Our Case Number: ABP-316025-23

Re: Wind energy development including 19 turbines and all associated works.
Townlands of Clogherachullion, Cloghercor, Derryloaghan, Aghayeevoge, Cashelreagh Glebe,
Darney, Drumard, and Drumnacross Co. Donegal

Submission on Planning Application Number 316025 Cloghercor Windfarm.

Figure 13-4: Excerpt from the current Donegal County Development Plan 2018-2024 showing scenic amenity designations in relation to the proposed project.

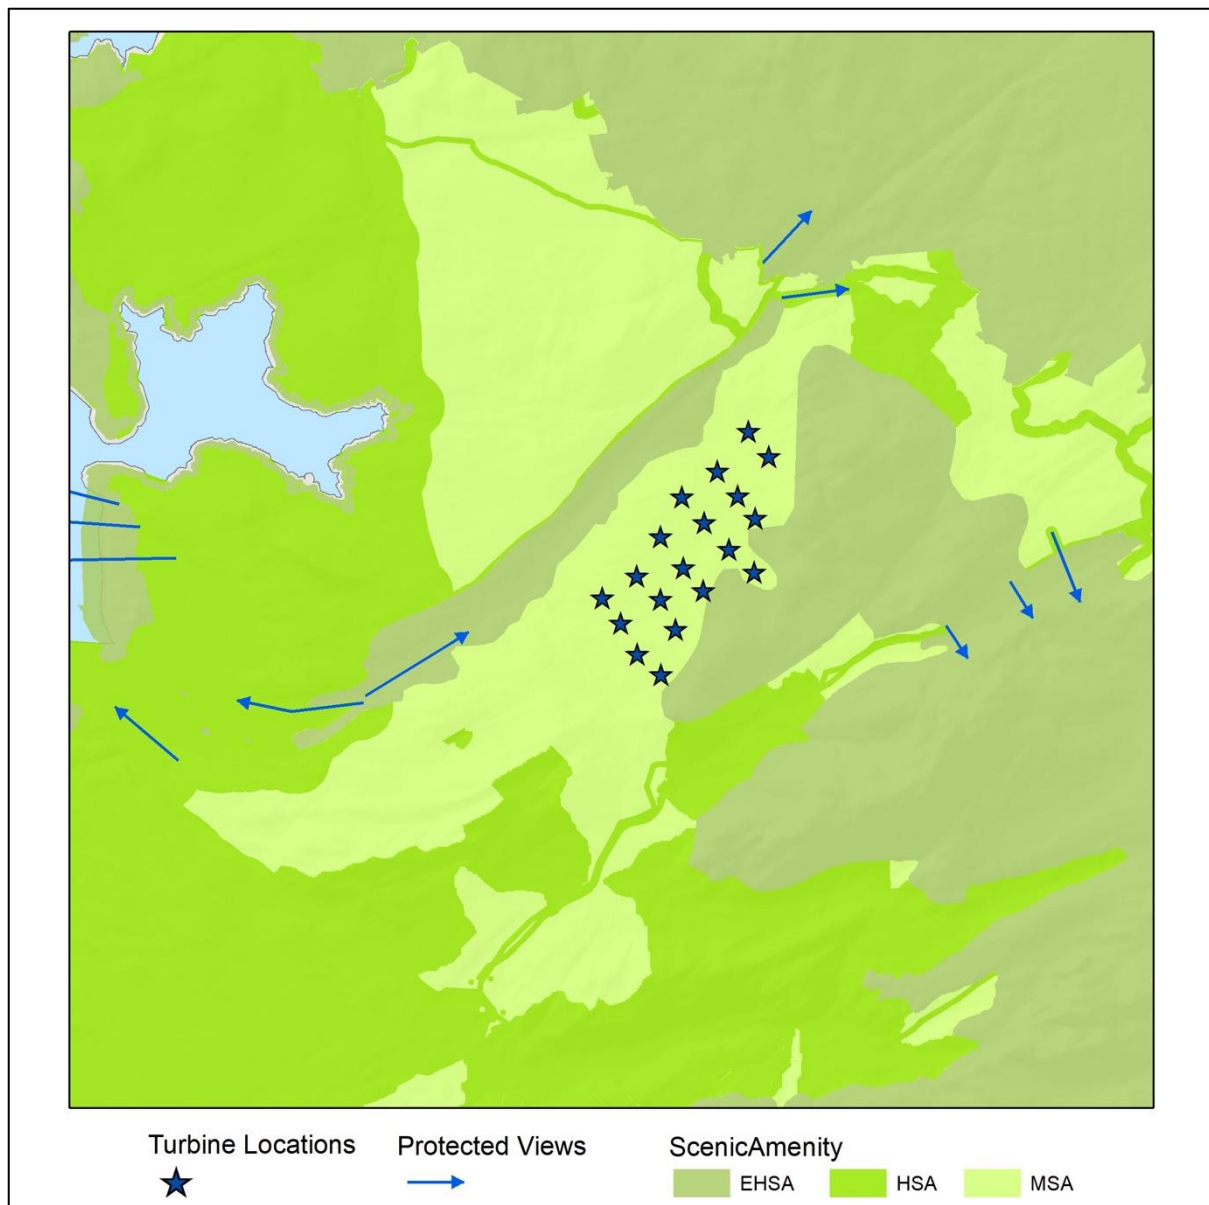
The LVIA chapter 13 of the planning application Figure 13.4 shows a map of scenic amenity in relation to the proposed development, Figure 13-8 ZTV shows the theoretical zone of visibility to 20km radius.

While turbine bases may all be placed within the boundaries of an area designated as MSA the turbine towers and rotors being among the tallest structures in the country, towering to tip heights of 200m, it is clear that from most vantage points within the Gweebarra Valley, many viewpoints within the numerous SPA's and SAC's in close proximity, from many parts of the Wild Atlantic Way and local roads and from within much of Glenveagh National Park the view of the turbines will dominate and obstruct the view towards HSA and EHSA areas, dominate distant views and present substantial skylining. This is clear when one considers that the lowest turbine stand, that of turbine 1, is at an elevation of approximately 60m. The other stands range in altitudes of up to 160m. This places the tip of the rotors at heights of between 260m to 360m, which is higher than the hills surrounding them except for the peak at Croaghleheen (380 – 385m), although viewing from the L1783 road on the north bank of the Gweebarra River opposite the site which at its highest point is less than 60m elevation will present substantial skylining of all turbines along its entire length, including against Croaghleheen. Had the ZTV extended another 5km it would show that all 19 turbines would be visible from the offshore islands and many additional coastal areas. This is clearly the case when the photomontages submitted with the application are examined.
